Planning & Urban Development Department

February 26, 2016

Re: 1637 -1643 Washington Avenue – 373-A-016 (split from 373-A-003) – the "Property" – R-3 Residential Zone

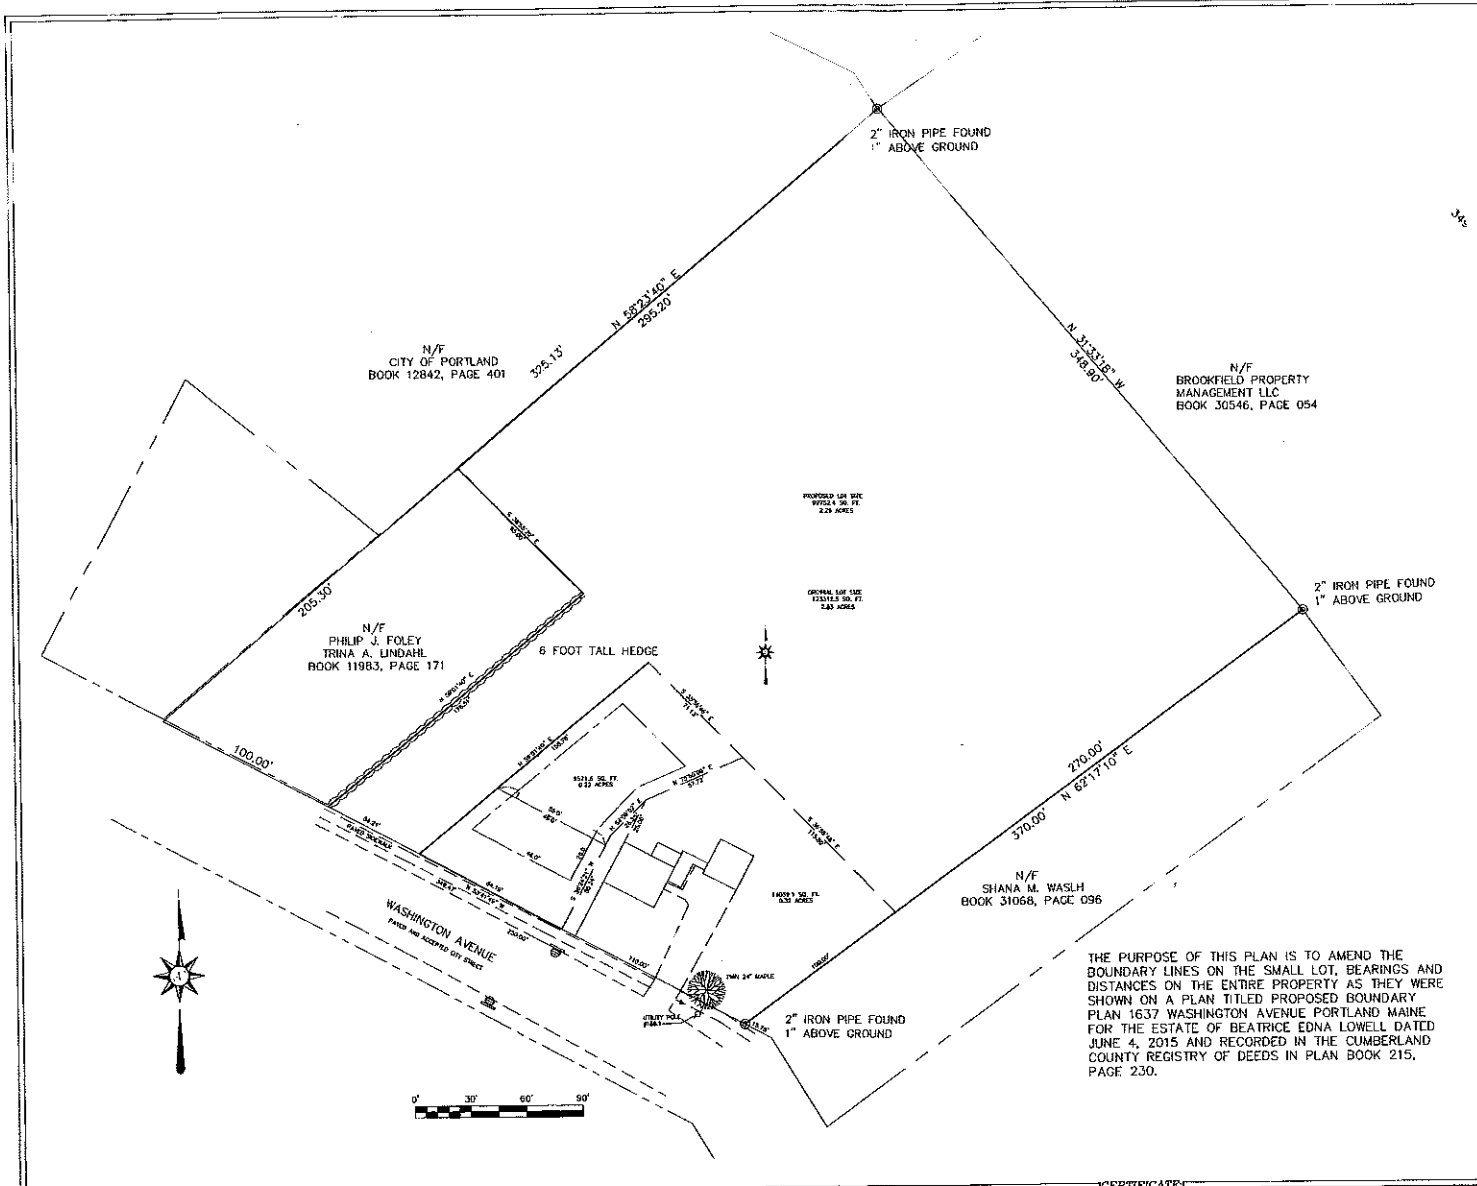
I am in receipt of your request for a zoning determination letter concerning the Property located adjacent to 1637 Washington Avenue. I have based my determination on Exhibit 2 Of: Proposed Lot Division, 1637 Washington Ave, Portland Maine for Stan and Sandy Towle prepared by Sebago Technics (attached). My determination is based on the dimensions that are shown on Exhibit 2, since it is not a full size scalable plan.

The Property is located in the R-3 Residential Zone. The dimensional requirements for this zone are outlined in § 14-80 of the Land Use Ordinance. My review of Exhibit 2 shows that the proposed 35' x 20' two story building with a one story 6' x 20' section located on the right side meets all the dimensional requirements of the R-3 Residential Zone as does the proposed 24' x 24', one and one half story detached garage. I must point out that the front steps shown on the principal building encroach into the front yard setback. § 14-425 allows a yard to "be occupied by a one-story entrance porch not enclosed with or without a roof, if the area of the porch does not exceed fifty (50) square feet nor the projection from the building exceed six (6) feet." The front steps shown on Exhibit 2 will be in compliance if they meet section 14-425.
